CITY OF ALBUQUERQUE

February 21, 2023

Re: Safety Counseling Office Building
2900 Wellesley Dr. NE
Traffic Circulation Layout
Architect's Stamp 02-13-23 (H16-D101)

A1 TRAFFIC CONTROL LAYOUT

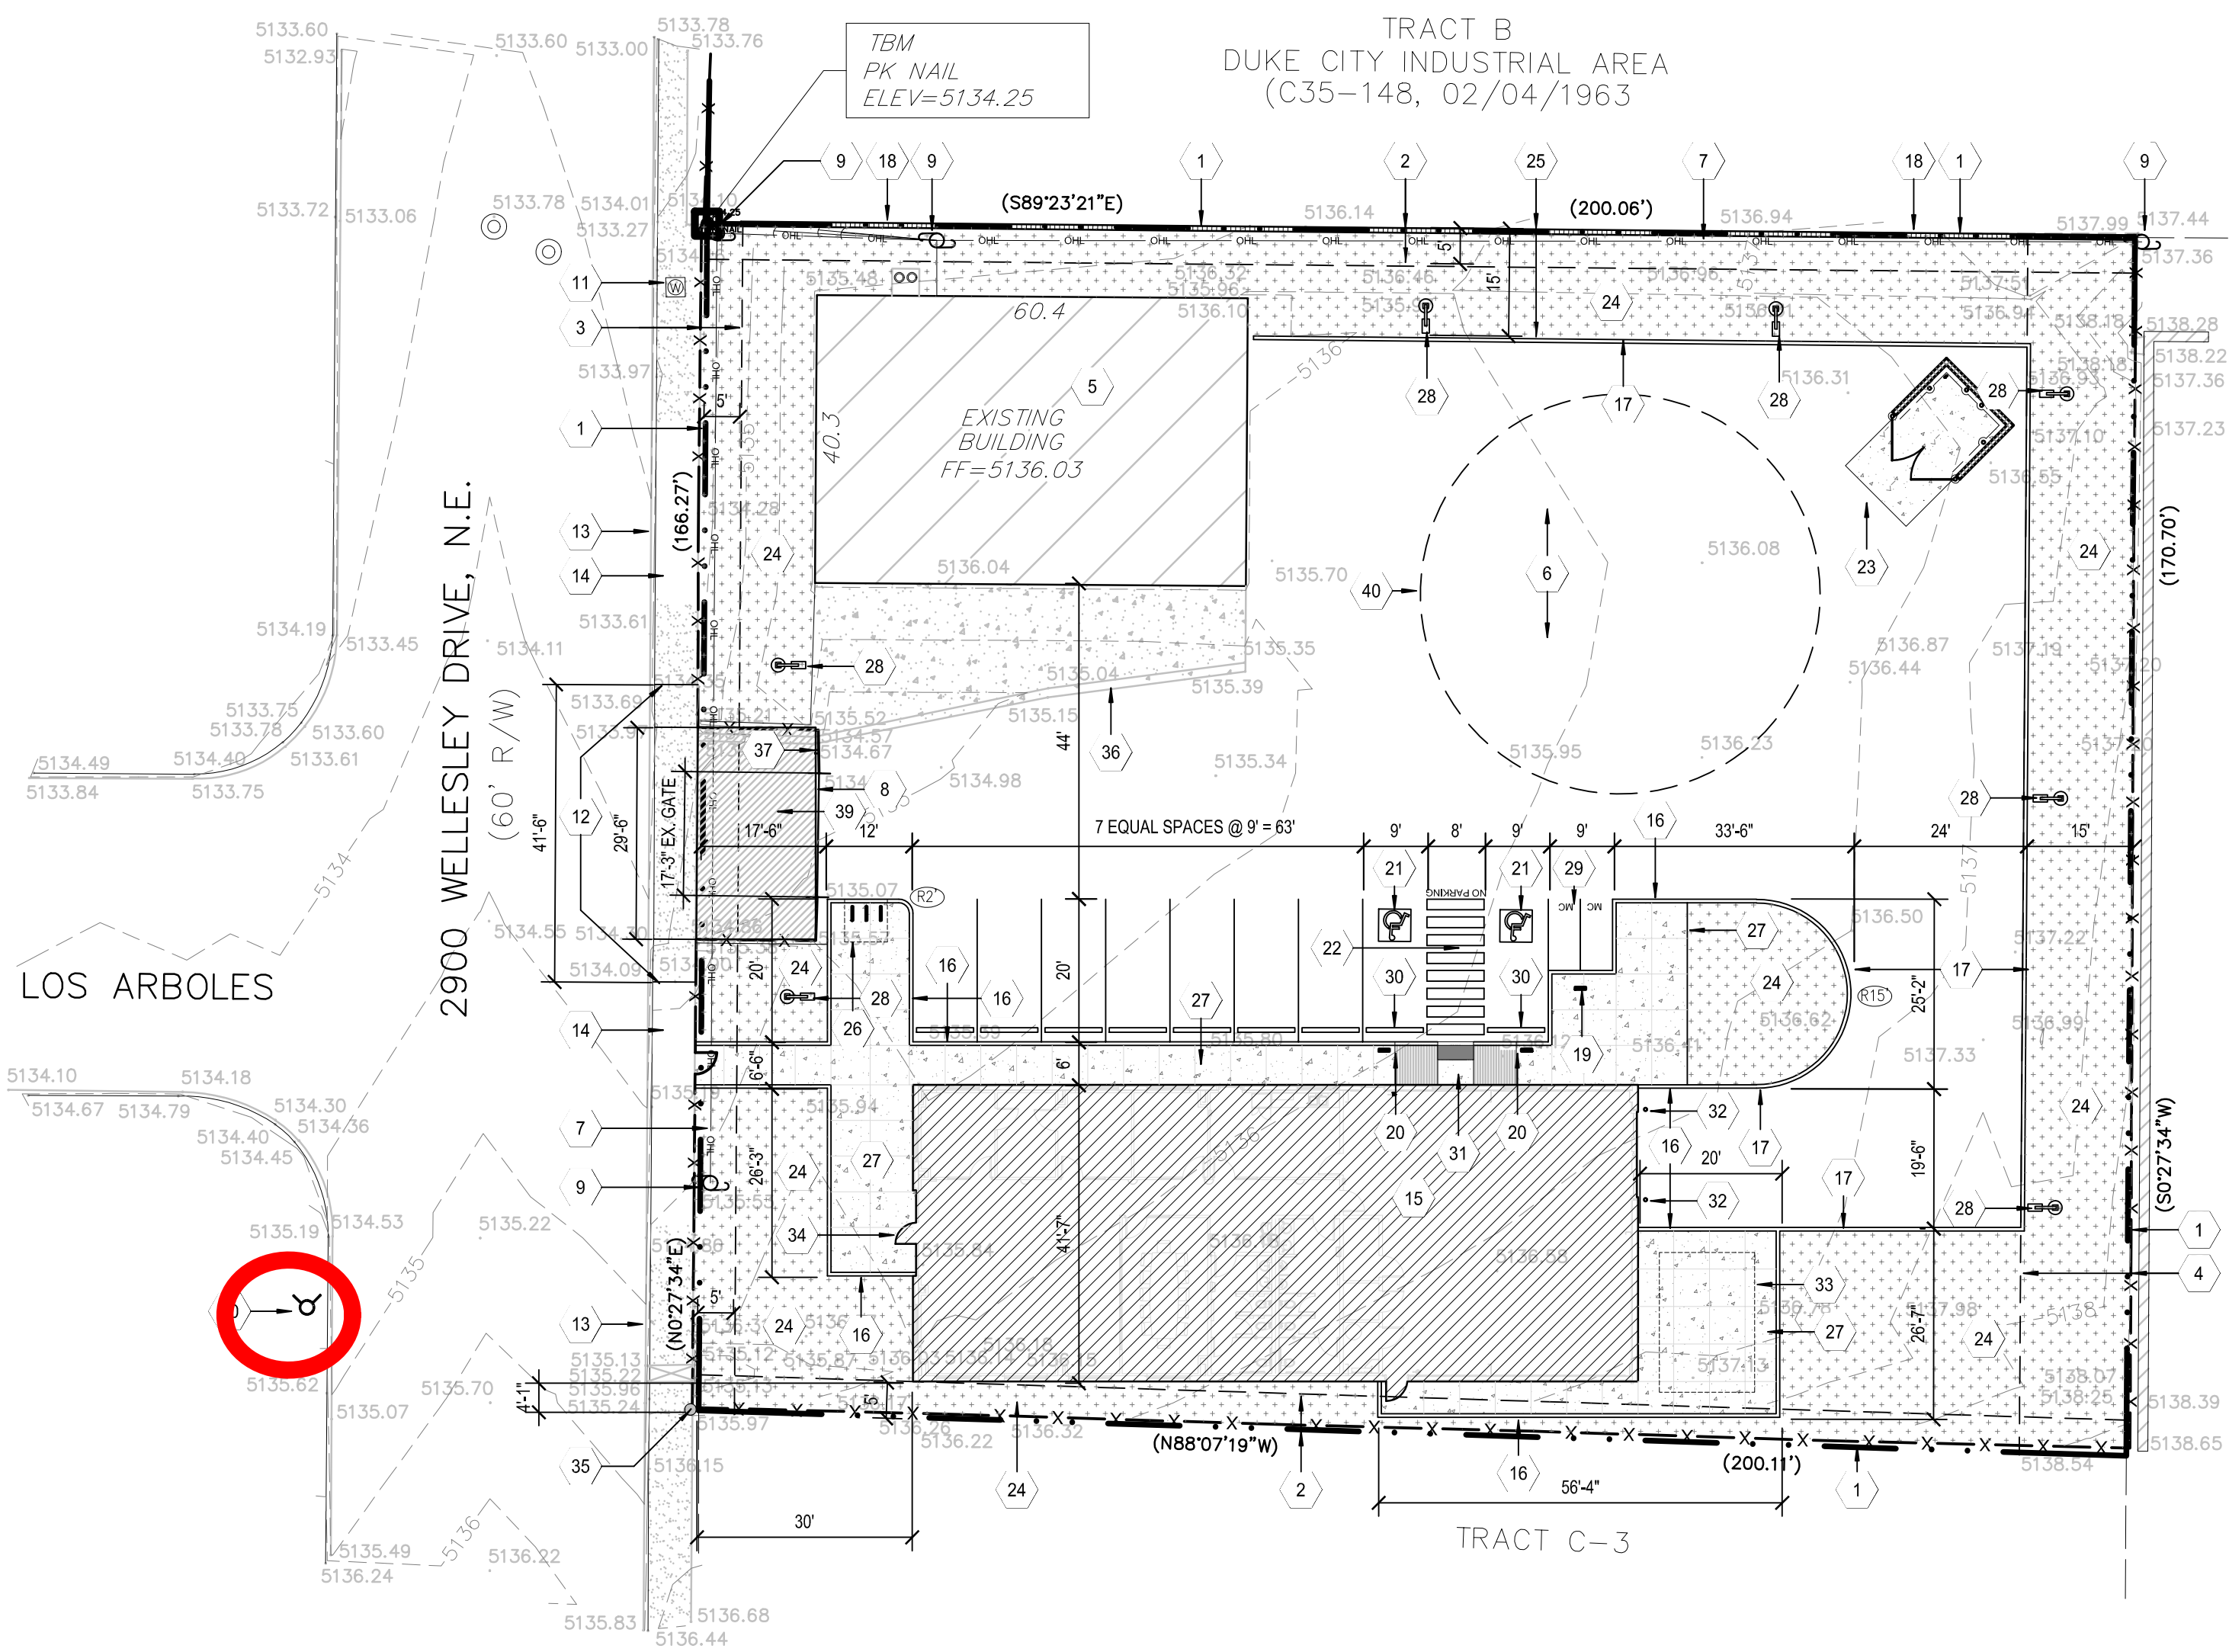
1. Identify all existing access easements.
2. Existing drivepad must be updated to current ADA standard. Please provide driveway width and design details.

3. Please see attached blue-marked site plan and provide the driveway width.
4. Please see attached highlighted site plan and define the ADA pathway from the public sidewalk by labeling of ramps or flush pavement.

5. Keynote 31: please show on the site plan 5'X5' ADA landing area, or Suggestion: refer to COA std dwg 2443 detail A-Parallel curb ramp.
6. Show the clear sight triangle and add the following note to the plan: "Landscaping and signage will not interfere with clear sight requirements. Therefore, signs, walls, trees, and shrubbery between 3 and 8 feet tall (as measured from the gutter pan) will not be acceptable in the clear sight triangle.

7. Refuse vehicle maneuvering shall be contained on-site. The refuse vehicle shall not back into the public right of way.; provide a copy of refuse approval.
